3 May 2012

Mixed Commercial and Retail Development (Stage1) – 2 Australia Avenue, Sydney Olympic Park

Andrew Brown
Executive Manager
Urban Planning and Design

drawing title
Ground Floor Swept Path:Service Area Exit

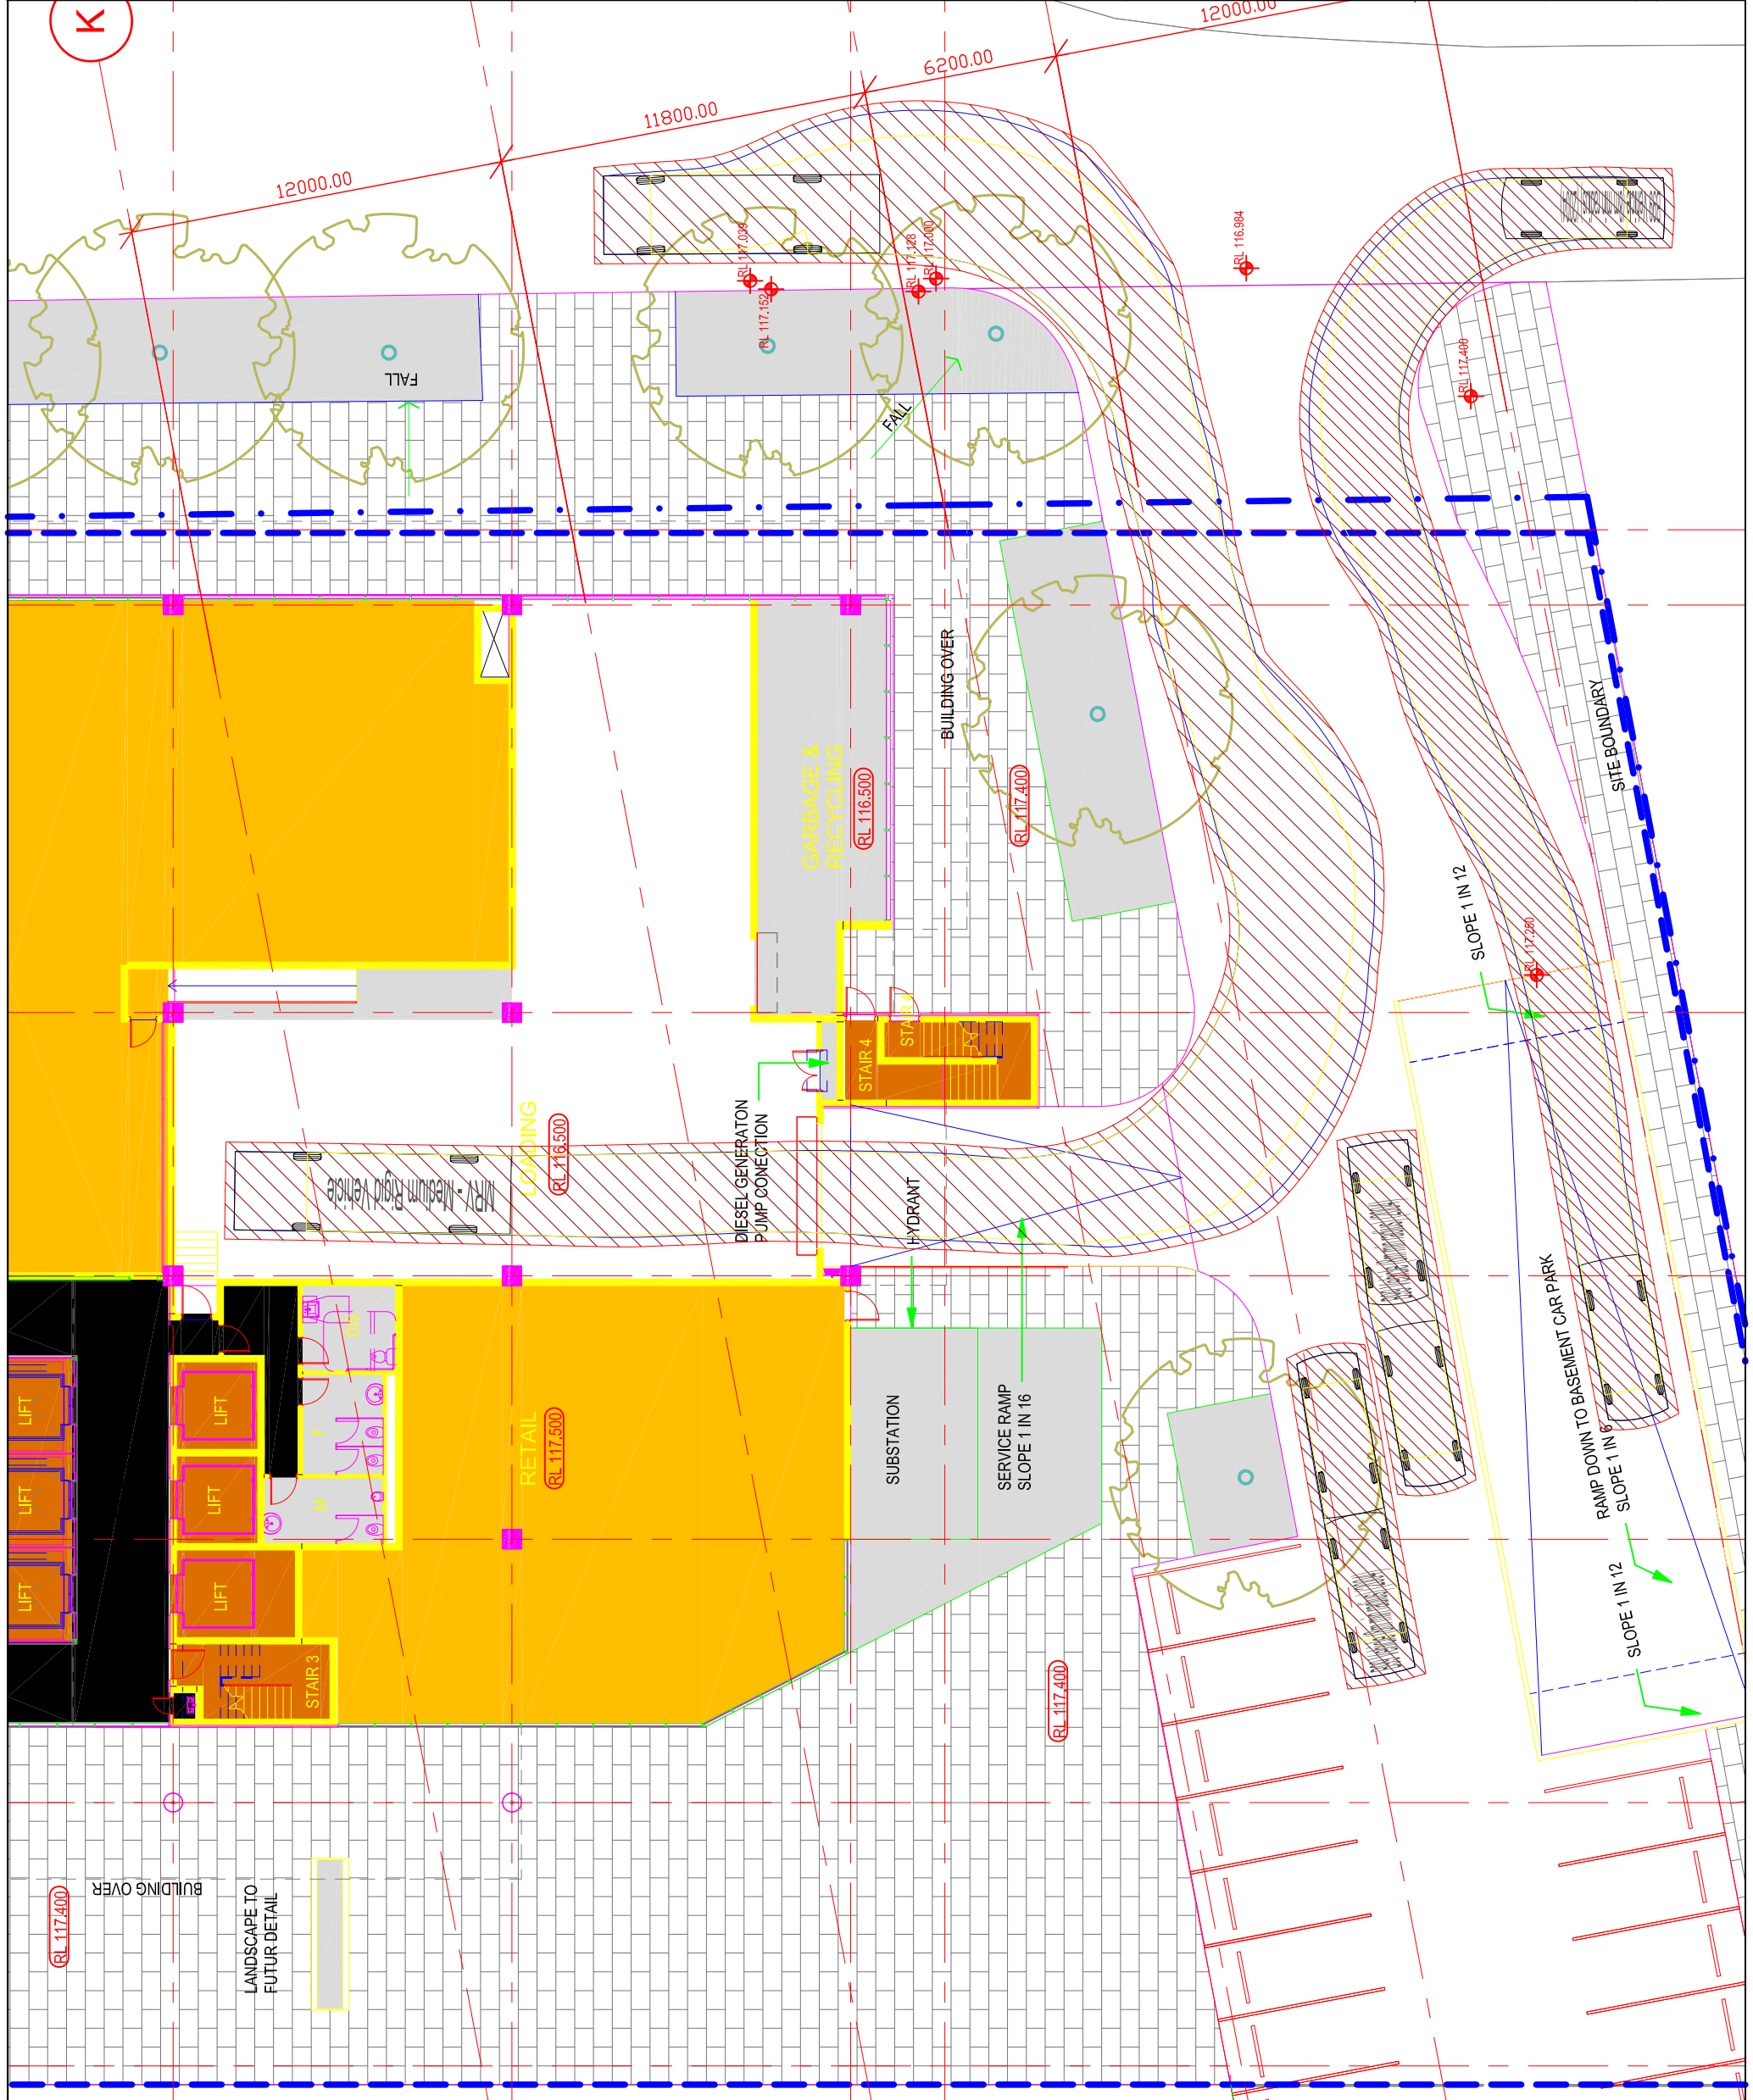
- 1) The use of AS 2890.1 (2004) for the northern most driveway where it is my understanding that AS 2890.2 (2002) is the appropriate standard;
- 2) The turntable design which utilises an 8.8 metre vehicle where it is still widely thought that vehicles up to 11 metres are the norm;
- 3) The signage associated with the operation of the supermarket car park will be instrumental in how it operates. Details will need to be provided as part of your response; and
- 4) The additional analysis of traffic modelling for the Australia Avenue and Sarah Durack intersection is noted and will be reviewed as part of your revised application.
